Application for Removal or Variation of a Condition following Grant of Planning Permission or Listed Building Consent

Demolition of existing dwelling and construction of a new dwelling

23/00331/FUL

Condition 2 There will be 5 minor changes to: Elevations, Drawing No: SF32353.1.P1 Revision: D2.2

<b>scales:</b>	<b>drawn:</b>	<b>date:</b>	<b>Dwg No:</b>	<b>rev:</b>
1:50, 100 @ A1	G. Mathieson	08.2023.	SF32353-001	B

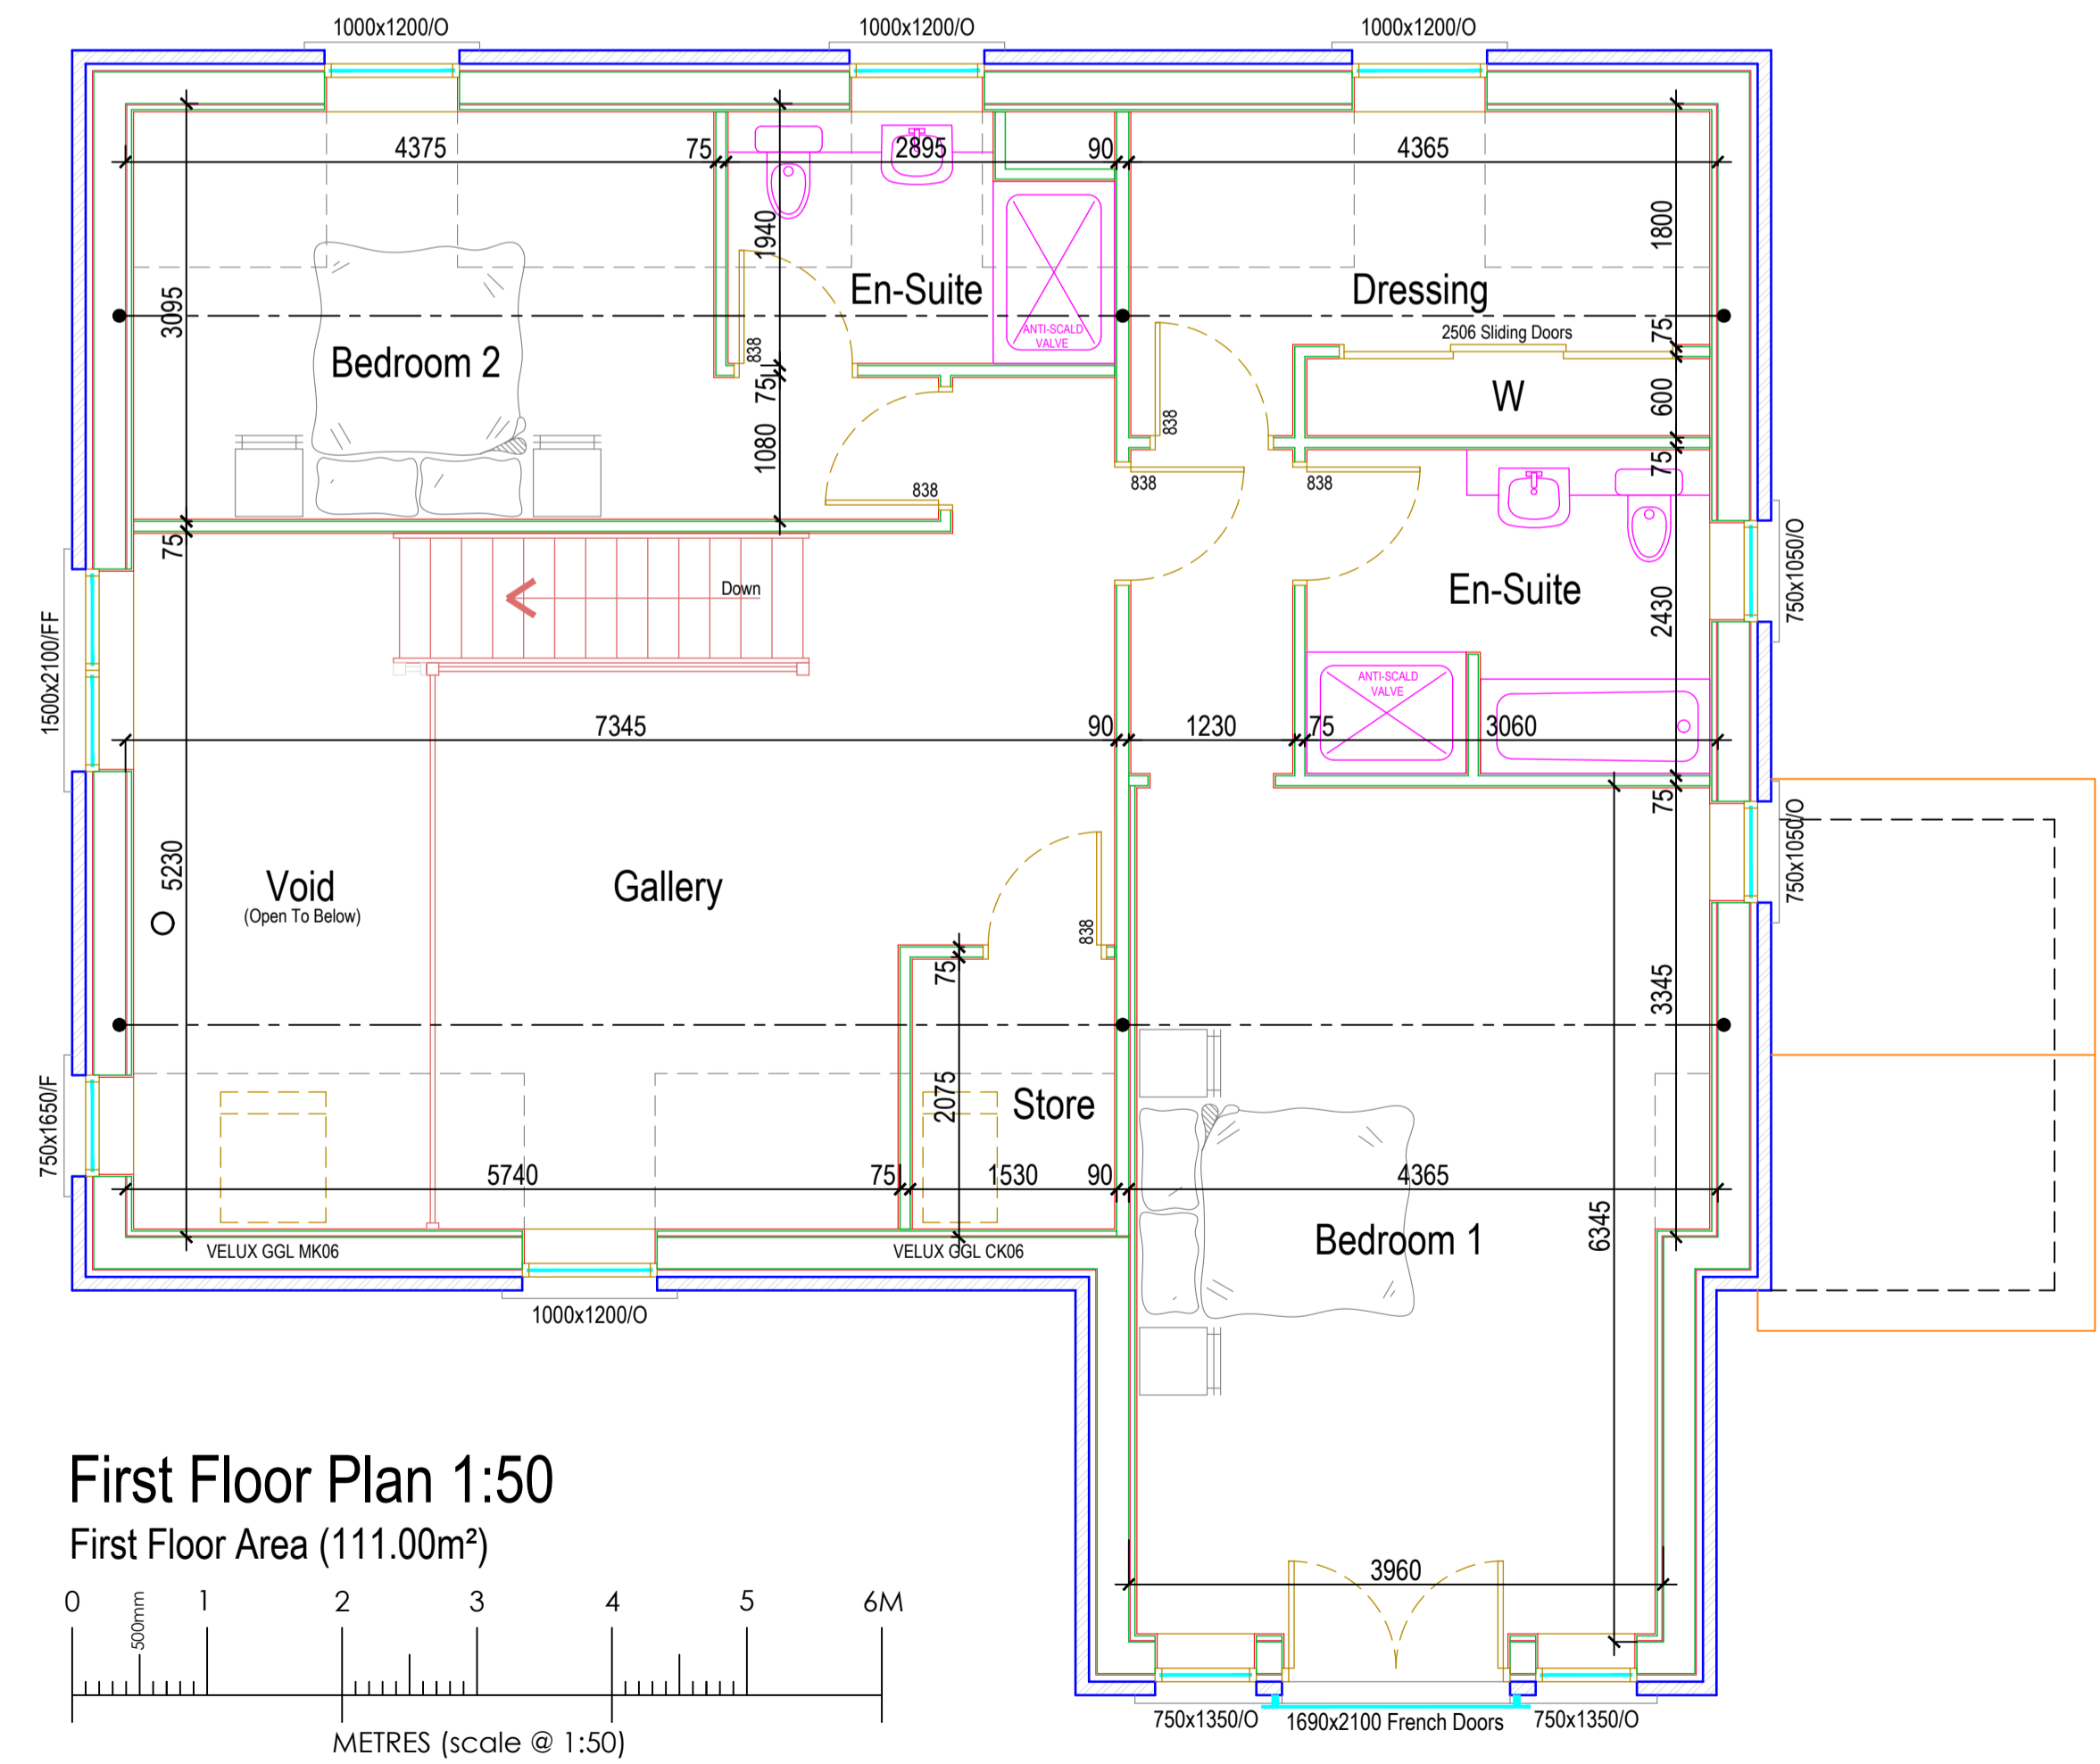
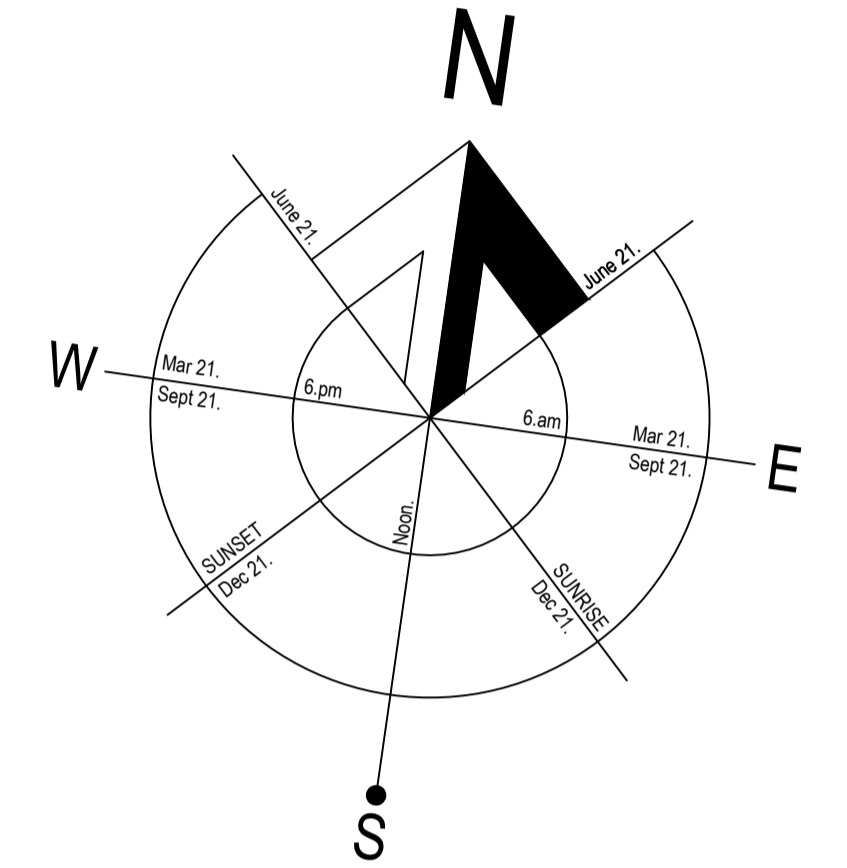
1. Reduction of the angle of the roof pitch by 5 degrees from 40 to 35 degrees 2. Reduction in the size of the first floor feature window on the South West corner of the West Elevation (removal of 'triangle') 3. Replacement of timber infill above and below feature windows with natural stone 4. Pergola to the front of the South elevation (in front of lounge dining area) 5. Adjustment to the layout of solar PV panels on the South facing roof

1. Reduction of the angle of the roof pitch by 5 degrees from 40 to 35 degrees The reduction in the roof pitch by 5 degrees will allow the height of the ridge to be dropped very slightly to just 7.67 metres (a non-material drop of just 2 centimetres) and the eaves height to rise sufficiently to allow better use of the first floor roof-space. This minor change would increase the volume slightly to 862 cubic metres and thus have 47% more volume than the existing bungalow, just 2.7% more volume than the approved plan (approved plan 846 cubic metres). The approved footprint of 137.28 square metres would remain completely unchanged.

2. Reduction in the size and change of shape of the first floor feature window on the South West corner of the West Elevation. All other approved windows are rectangular in shape and have a horizontal stone lintel above.

3. Replacement of timber infill above and below feature windows West Elevation with natural stone All other approved windows and doors have a stone lintel above and stone sill below.

4. Pergola to the front of the South elevation (in front of lounge dining area) A pergola was a critical part of the originally submitted plans. The revised plans left out the pergola in error. The pergola will support vines. This feature will allow unrestricted solar gain in the winter months but will help to reduce excessive solar gain in summer months.

5. Adjustment to the layout of solar PV panels on the South facing roof The approved layout of the 12 solar PV panels has them dispersed across the roof in two separate arrays. The proposed minor change is to re-align the 12 solar PV panels so they are all together in a single array which is 'integral' to the roof.
